Our Ref: Response to OEH matters_Lachlans Line

RE: Modification of pedestrian bridge over Delhi Road and the M2, North Ryde Station Urban Activation Precinct (Lachlan's Line) - SSD 5093 MOD 4

Thank you for forwarding the response to submissions from the Office of Environment and Heritage. Please find below responses from Landcom to the matters raised in Attachment 1 of the Office of Environment and Heritage letter of 23 July 2018 as follows:

PROJECT NEW DEVELOPMENT			
DRAWING TREE LOCATION PLAN - PIER 1			
SCALE N.T.S. @ A3	ISSUE REF	SHEET T - 02	
DRAWN LD+AM	CHECK AM	DATE 22-05-18	REVISION J

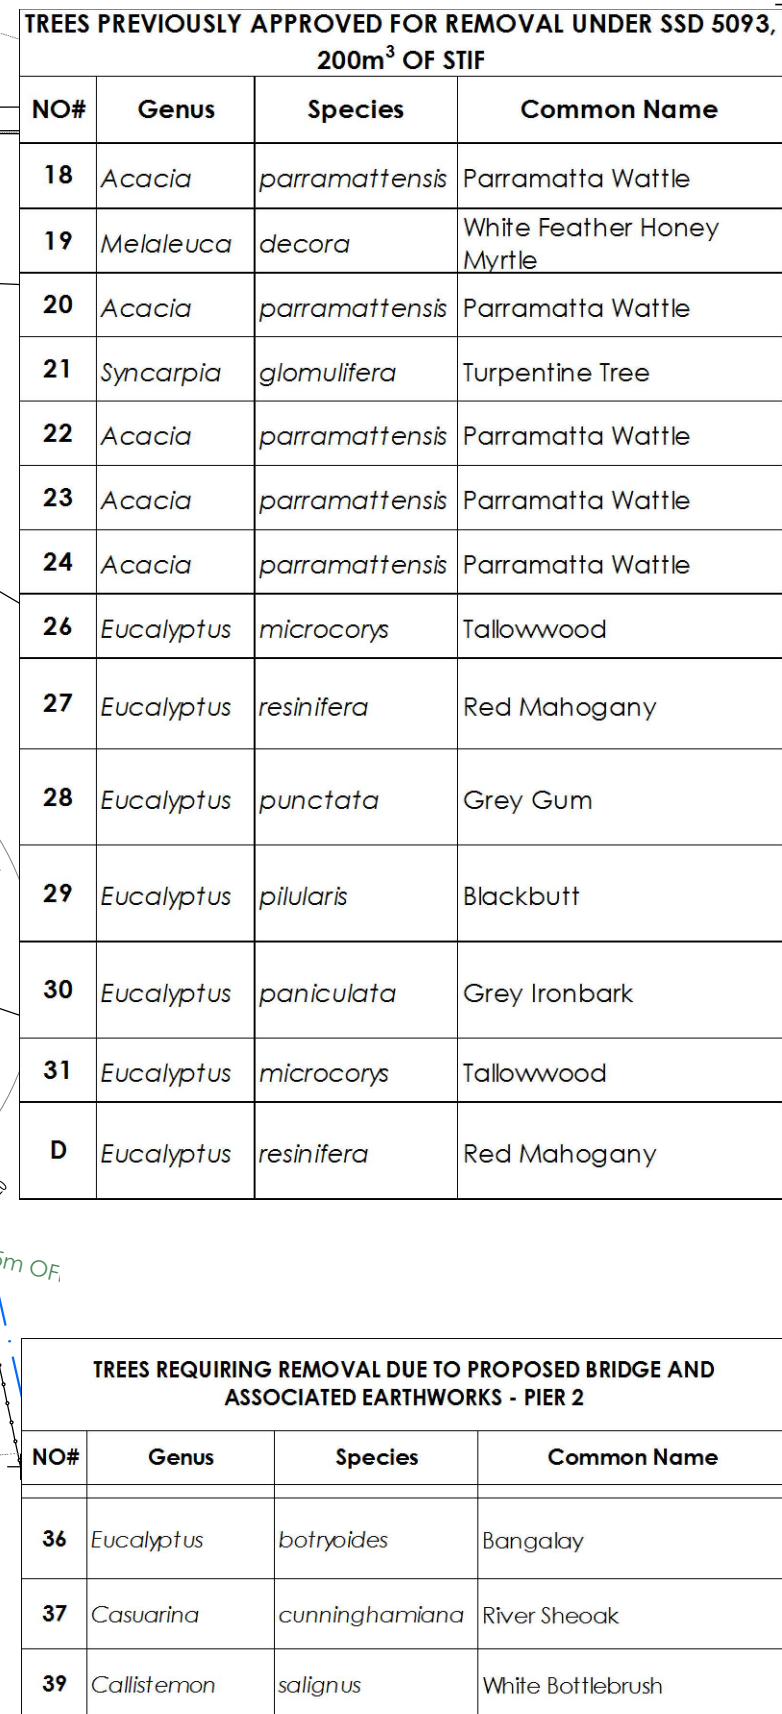
The amended Arborist report still refers to a 5m buffer and on the tree location plans for Piers 1, 2 and 3 does not show the amended 3m buffer whereas the original plans depict the buffer area. Please clarify how many trees are proposed to be removed in the 3m buffer area.

Pier 1:

- Tree 1 - given its location on the periphery of Pier 1 consider its retention
- Trees 3 and 4 – these trees were originally assessed as located in the fall zone (should they fall over in an unforeseen circumstance and impact on the bridge, and these trees in the fall zone were identified due to their heights or potential mature heights). It is noted they are currently 6m in height and it is not considered that their removal based on height is warranted. Further, they are located outside of the amended 3m buffer and 5m original buffer area so it is unclear why they are proposed to be removed and are also on the periphery of the earthworks area.

The trees to be removed inside the RMS 3m maintenance zone are identified in Table 1 below:

Table 1: Trees within the RMS 3m maintenance zone

Pier 1			
T1	Callistemon	salignus	White Bottlebrush
T8	Callistemon	viminalis	Weeping Bottlebrush
Pier 2			
T37	Casuarina	cunninghamiana	River Sheoak
T39	Callistemon	salignus	White Bottlebrush
Pier 3			
T149	Syncarpia	glomuilera	Turpentine
T152	Eucalyptus	acmenoides	White Mahogany
T156	Eucalyptus	acmenoides	White Mahogany

- none of the trees proposed to be removed within the 3m RMS maintenance zone are of high or medium significance
- 3 high significance trees; T10 (Turpentine) at Pier 1, T11 (Turpentine) at Pier 1, and T150 (Turpentine) at Pier 3, can now be retained as a result of the RMS maintenance zone reducing from 5m to 3m.

Tree Removal				
Pier 1				
T1, T3, T4	Callistemon Allocasuarina Allocasuarina	salignus littoralis littoralis	White Bottlebrush Black Sheoak Black Sheoak	<p>These trees are impacted by the work zone required to construct the abutments and bridge lifts.</p> <p>Each tree is identified by a qualified arborist as being non-significant, typical of a native roadside planting.</p> <p>Landcom will replace these with new appropriate low scale native plantings to preserve RMS maintenance zone</p>
Pier 2				
T36 T37 T39	Eucalyptus Casuarina Callistemon	Botrioides Cunninghamiana salignus	Bangalay River Sheoak White Bottlebrush	<p>The Sheoak and Bottlebrush are within the RMS 3m buffer zone.</p> <p>They, and the Bangalay are also impacted by the work zone required for access to construct the abutments and bridge lifts (agreement has been reached with Council on their removal and replacement).</p>

PROJECT		NEW DEVELOPMENT			
DRAWING		TREE LOCATION PLAN - PIER 2			
SCALE	N.T.S. @ A3	ISSUE	REF		SHEET
DRAWN		CHECK		DATE	REVISION
LD+AM		AM		11-04-18	H

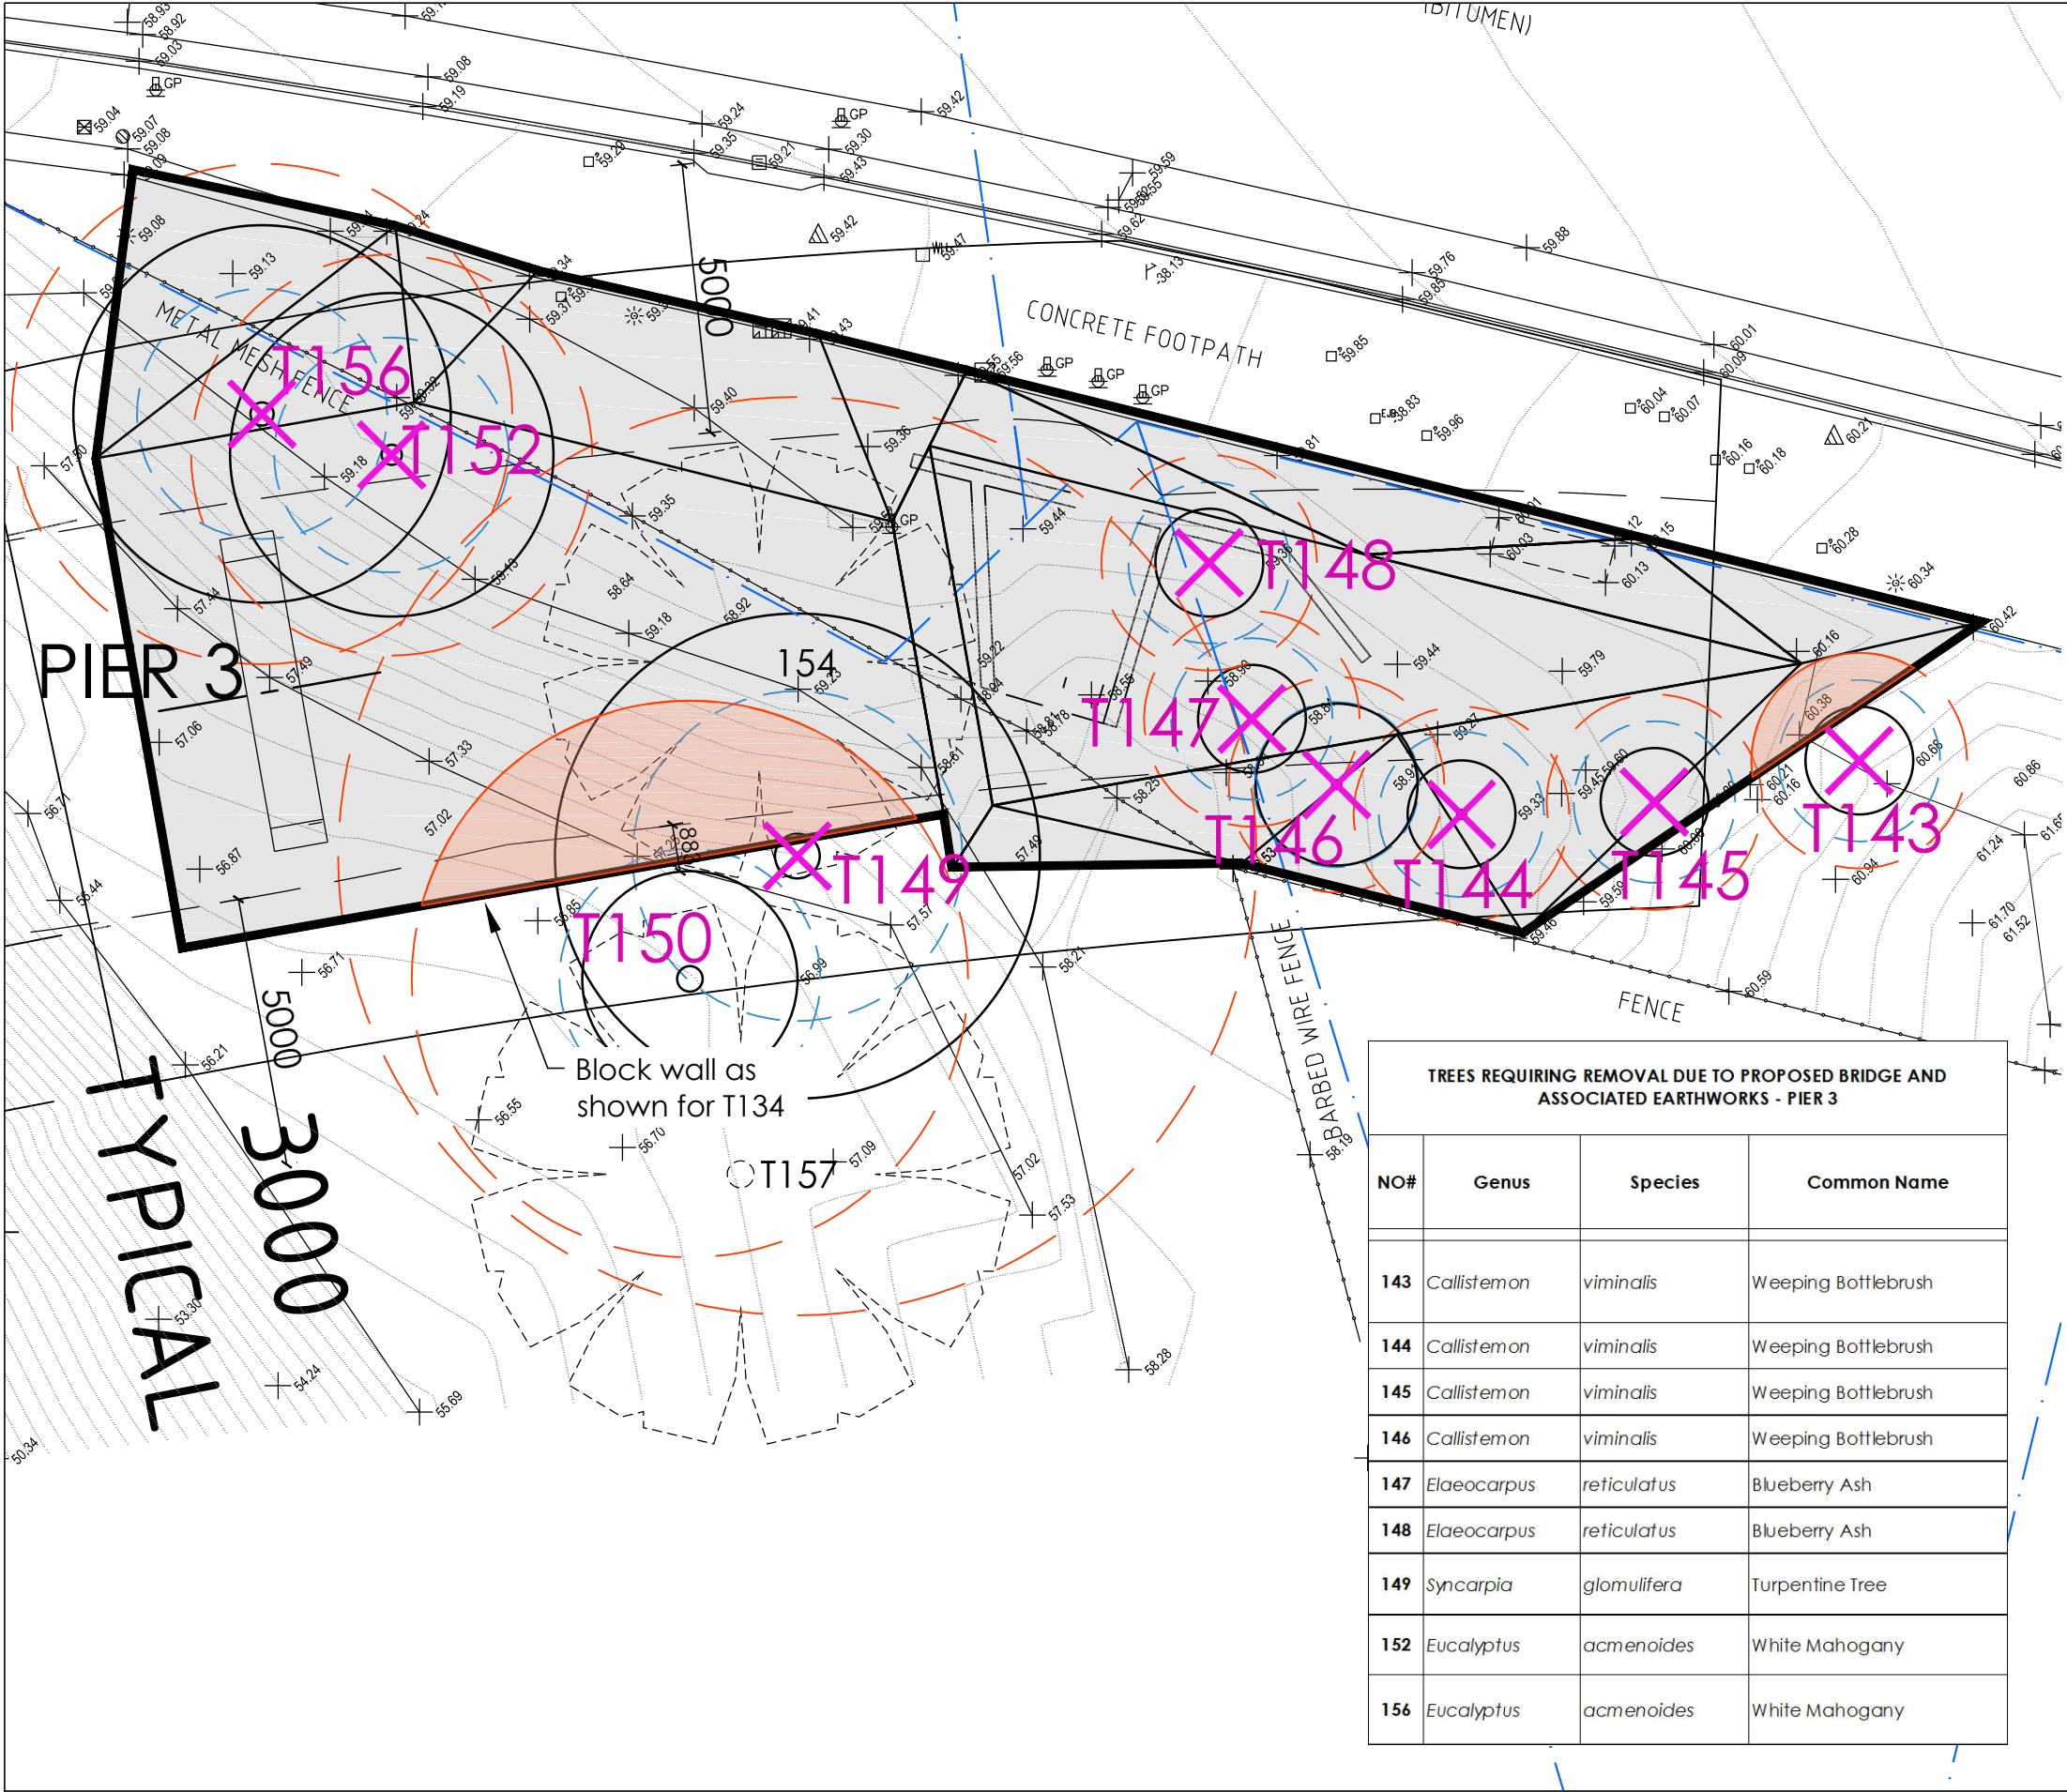
Pier 2:

- Tree 36 – this tree is located outside of the area required for earthworks and is 0.58m away from the proposed rig platform with a 25.8% encroachment in the TPZ which appears minor. It was originally assessed within the fall zone and is also outside of the amended 3m buffer area and 5m original buffer area so it is unclear why it is proposed to be removed.
- Trees 37 and 39 - were originally assessed to fall within the 5m buffer area and given this has been amended down to 3m are likely to now fall outside of the 3m buffer area. Given this it is unclear why these trees are proposed to be removed.

Tree Removal				
				<p>Each tree is identified by a qualified arborist as being of low significance.</p> <p>Landcom will replace with new appropriate low scale native plantings characteristic of STIF community, to preserve the RMS maintenance zone in accordance with a VMP to Council's satisfaction.</p> <p>Offset credits will be purchased and retired to mitigate impact.</p>
Pier 3				
T143	Callistemon	viminalis	Weeping Bottlebrush	<p>This tree is impacted by the work zone access required to construct the abutments and bridge lifts.</p> <p>This tree is identified by a qualified arborist as being non-significant, typical of a native roadside planting.</p> <p>Landcom will replace with new appropriate low scale native plantings to preserve RMS maintenance zone</p>
